Date: 5 December 2017

**PLANNING ACT 2008 – INFRASTRUCTURE PLANNING REGULATIONS 2017 –  
APPLICATION BY HIGHWAYS ENGLAND FOR DEVELOPMENT CONSENT FOR  
A585 WINDY HARBOUR TO SKIPOOL IMPROVEMENT**

Thank you for your letter of 9 November 2017 inviting the County Council's comments on a scoping report for the above proposed development.

ENGINEERING SECTION DRAWINGS
REGULATION 5(2)(o), 5(2)(p) & 6(2)
PROPOSED BORROW PIT
CROSS SECTIONS
SHEET 6 OF 6

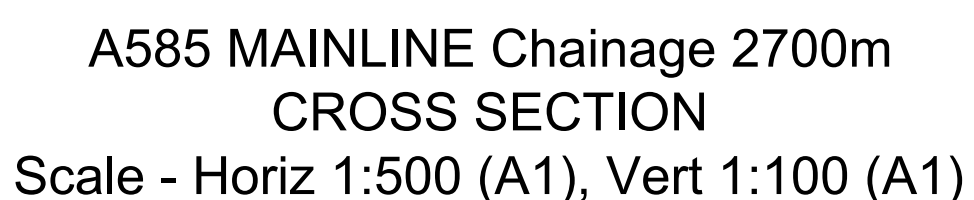
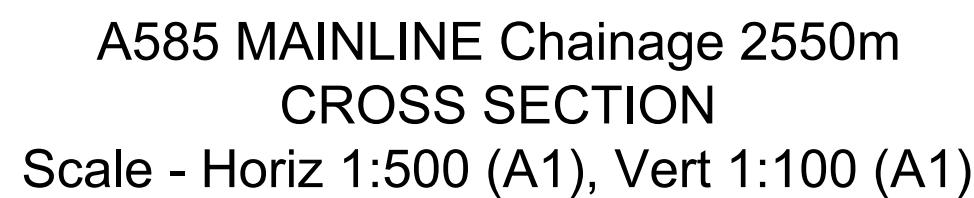
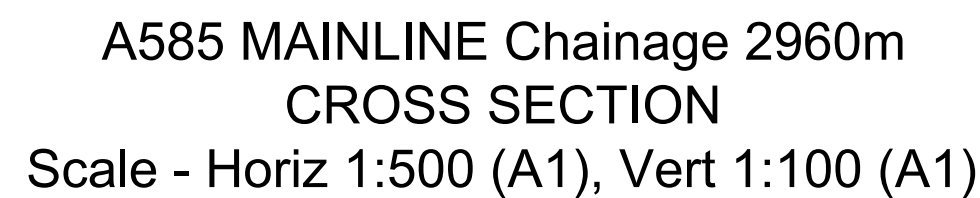
Section 2.6.3: The report makes reference to the proposal for two borrow pits to be developed to provide additional materials to construct the road. Figure 1.2 showing the general alignment and main features of the scheme only shows one borrow pit location and no details are provided as to the location of the second borrow pit. The ES should contain details of and assess the environmental impacts of all the major components of the scheme including any adjacent land which is to be used to source construction materials.

It is also noted from paragraph 2.6.3 that the borrow pit locations would be designed to allow the land to be returned back to agriculture on completion of excavation works. The means of restoration should be explained in the ES as presumably it will require some importation of additional material to achieve satisfactory levels following material being removed for use in the construction of the scheme.
